Recommendation Report for Lawful Development Certificate for a Proposed Use or Development**REF NO:** A/152/25/CLP**LOCATION:** Land West of Avenals Barn
Water Lane
Angmering
BN16 4QS**PROPOSAL:** Lawful Development Certificate for the proposed installation of 6 No. rooflights.**DESCRIPTION OF APPLICATION**

This application seeks a Lawful Development Certificate for the installation of 6 rooflights.

Proposed Roof Plan (Scale 1:50)

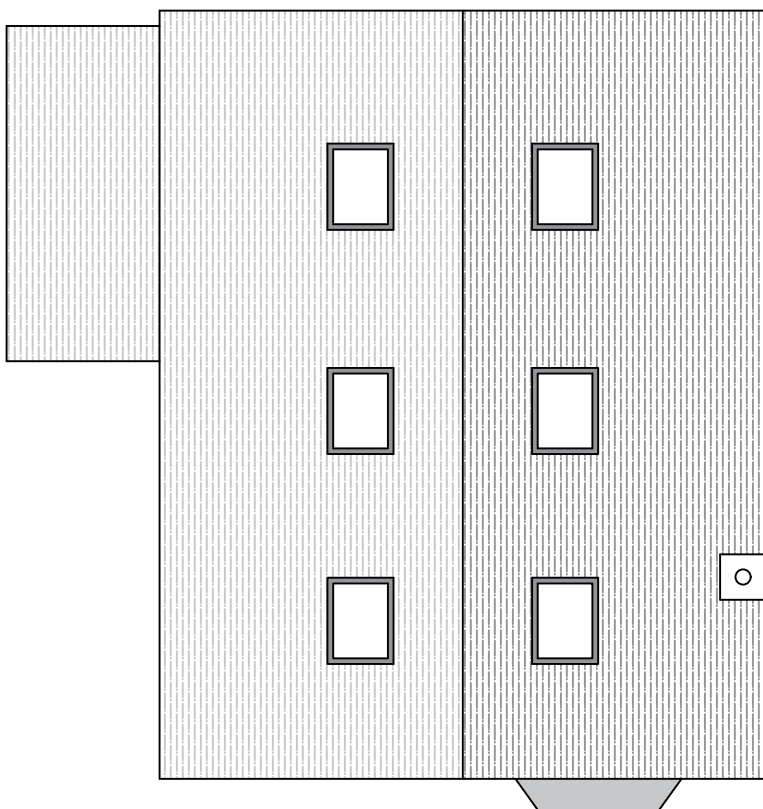
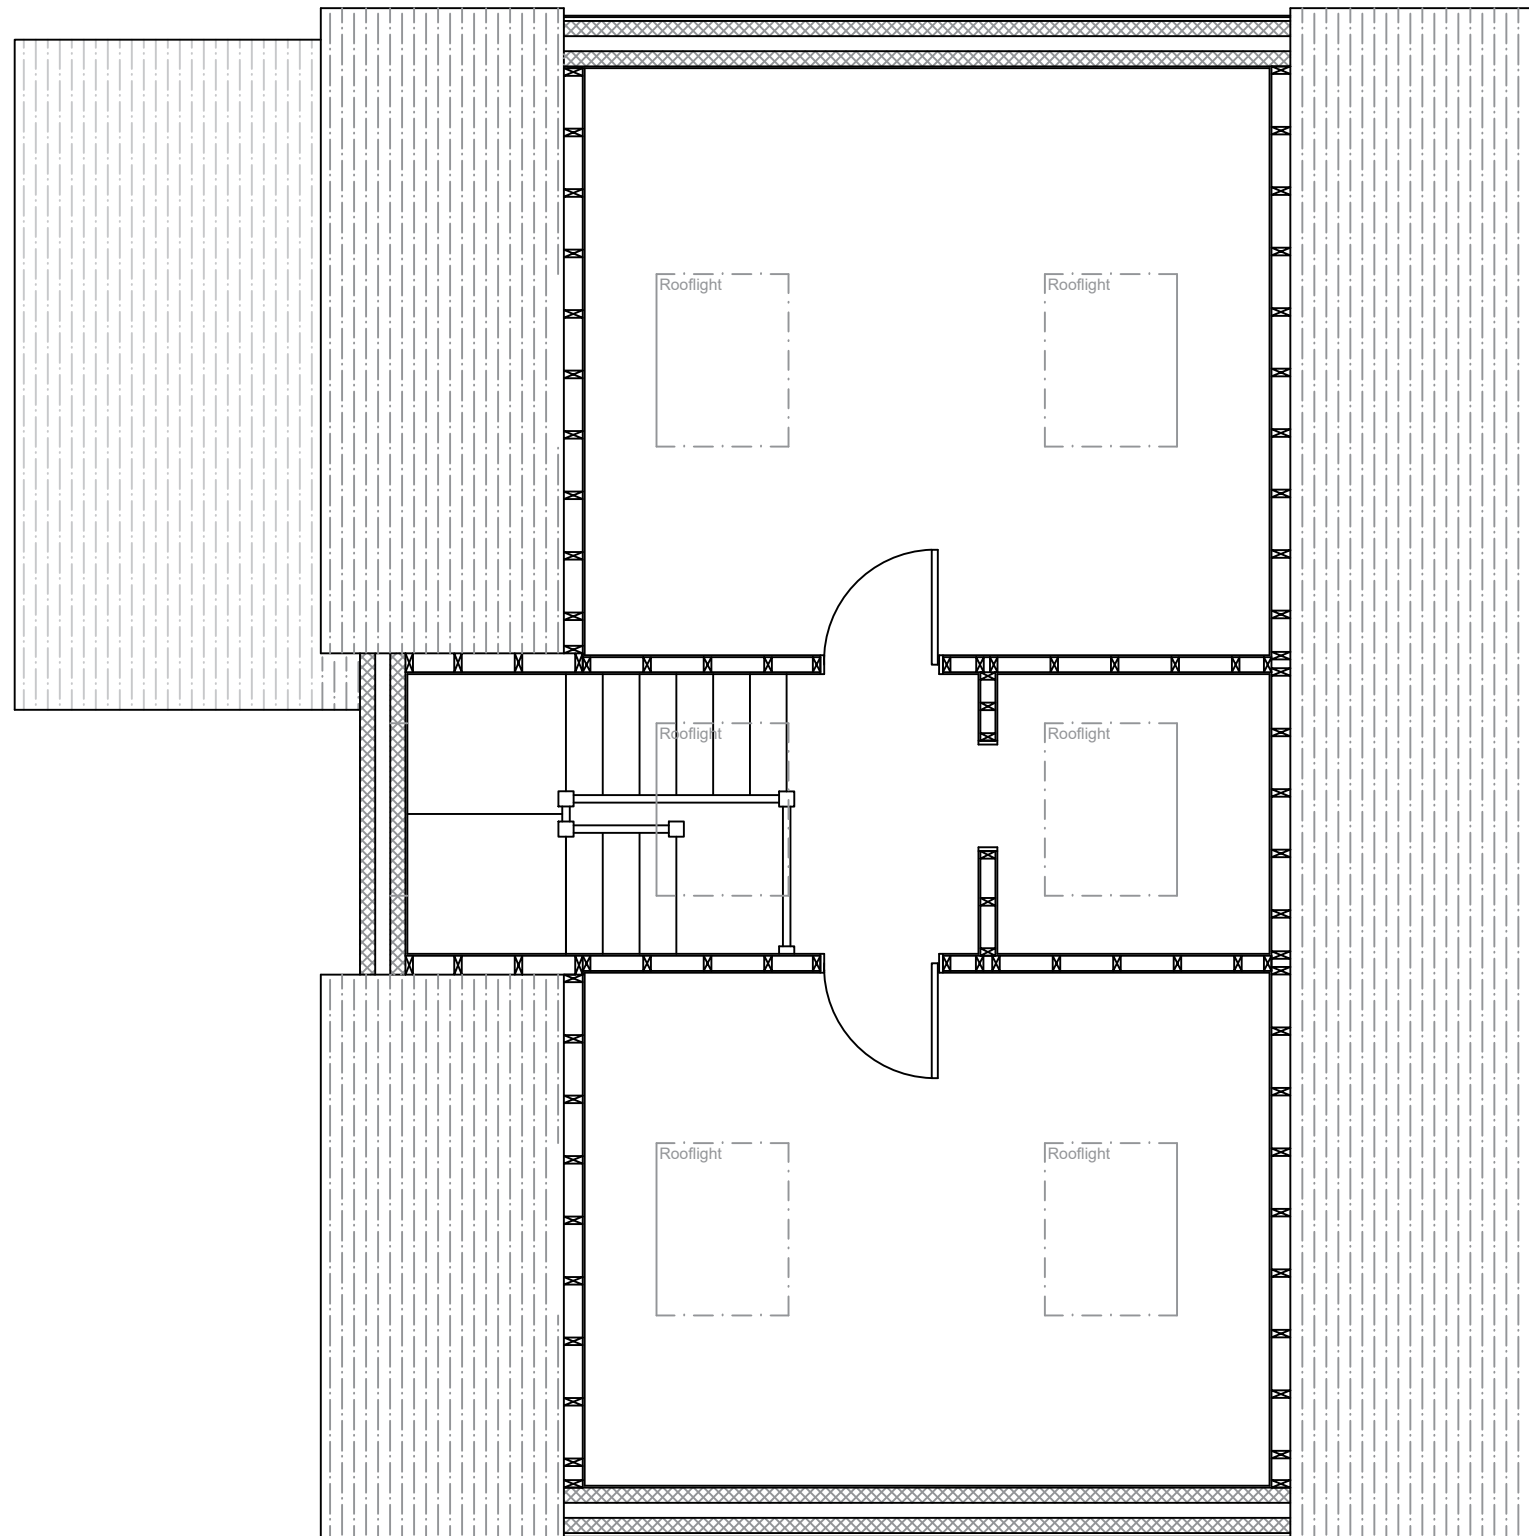
The proposed installation of 6 rooflights is considered to fall under Schedule 2, Part 1, Class C of the Town and Country Planning (General Permitted Development) (England) Order 2015 (as amended) (GPDO).

(b) the alteration would protrude more than 0.15 metres beyond the plane of the slope of the original roof when measured from the perpendicular with the external surface of the original roof;

C.2 Development is permitted by Class C subject to the condition that any window located on a roof slope forming a side elevation of the dwelling/house must be-

The installation of 6 rooflights complies with relevant sections of Schedule 2, Part 1, Class C of the Town and Country Planning (General Permitted Development) (England) Order 2015. The proposal is lawful and does not require the submission of an application for planning permission.
